## Department of Transportation

April 20, 2023

RE: Guntzelman Porcelain Pines Minor Subdivision  
MS 234 | Minor Subdivision

**PRE-DEVELOPMENT SUMMARY TABLE**

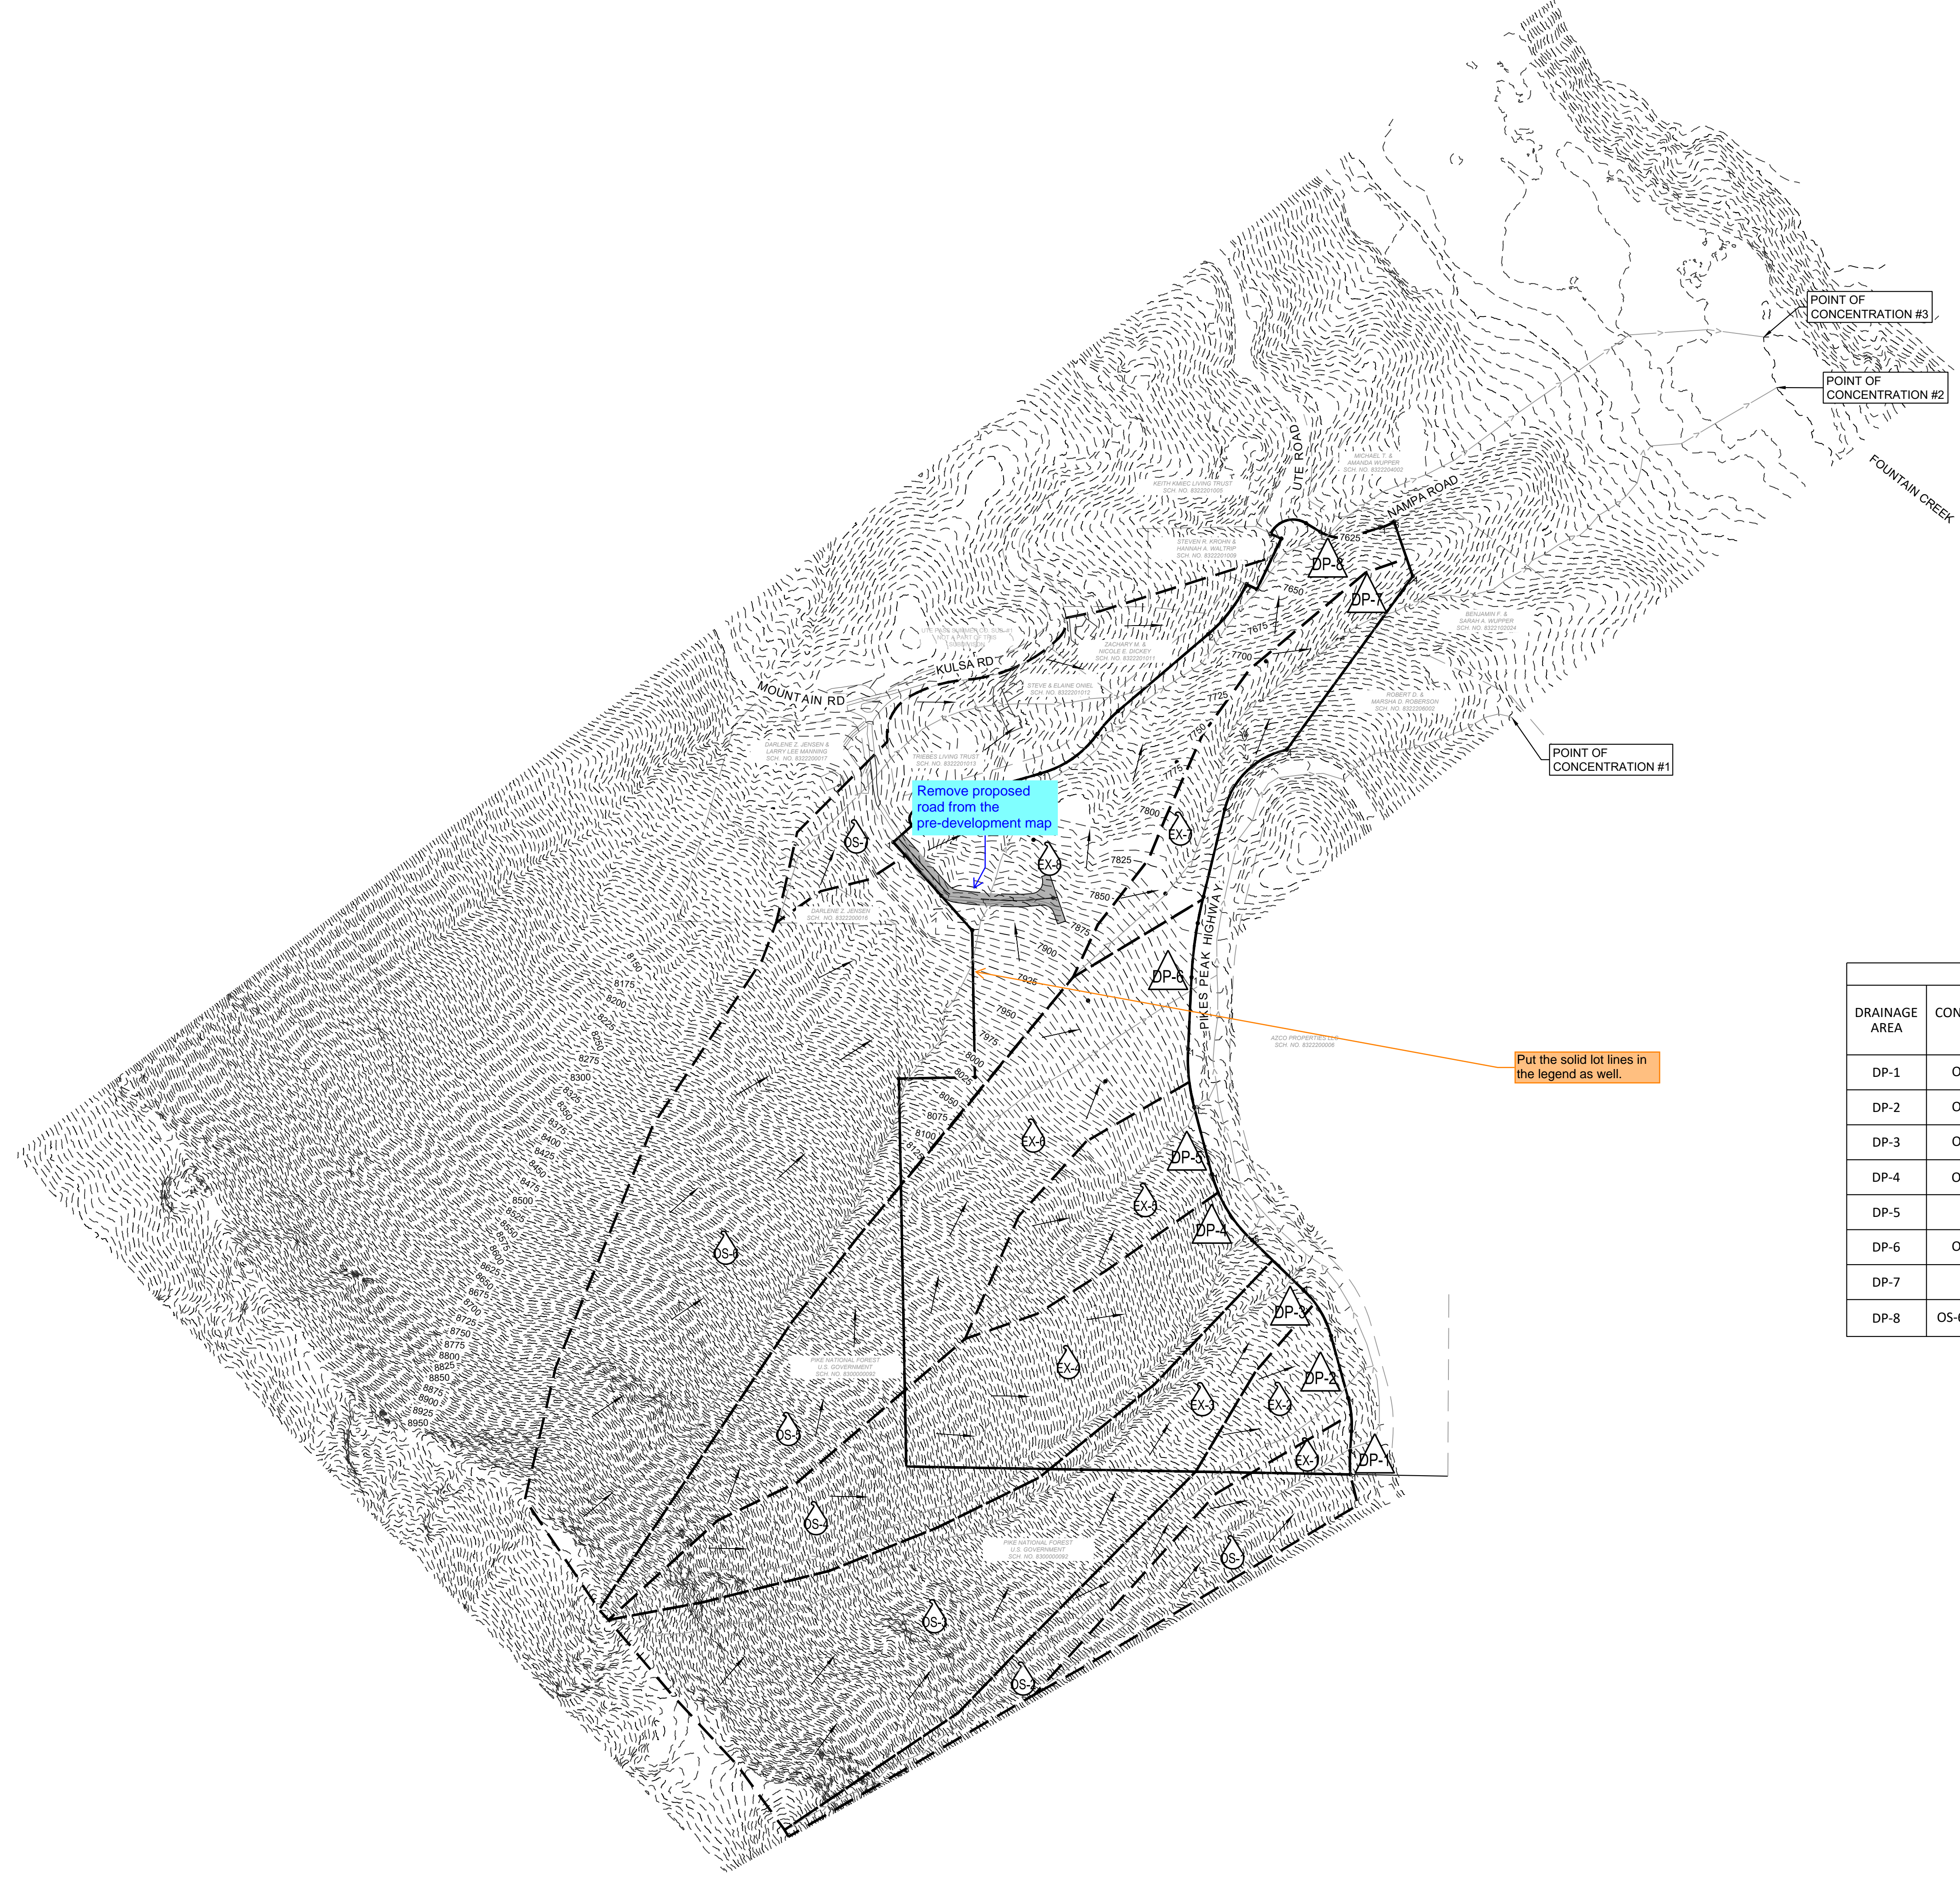
- Revise time of concentration lines and values for basins 1, 2, and 3 for both pre-development and post-development conditions.
  - Time of concentration lines should be drawn to the drainage basin outlet. Additionally, the proposed ditches will change the contours and will change the time of concentration lines and values for the impacted basins.
  - Update pre- and post-development peak flowrates accordingly.
- Verify that the proposed subdivision will not result in increased runoff to Fountain Creek and make design changes as necessary to minimize those impacts.
- Provide plans for the proposed roadside ditches and show proposed contours on the post-development drainage map.
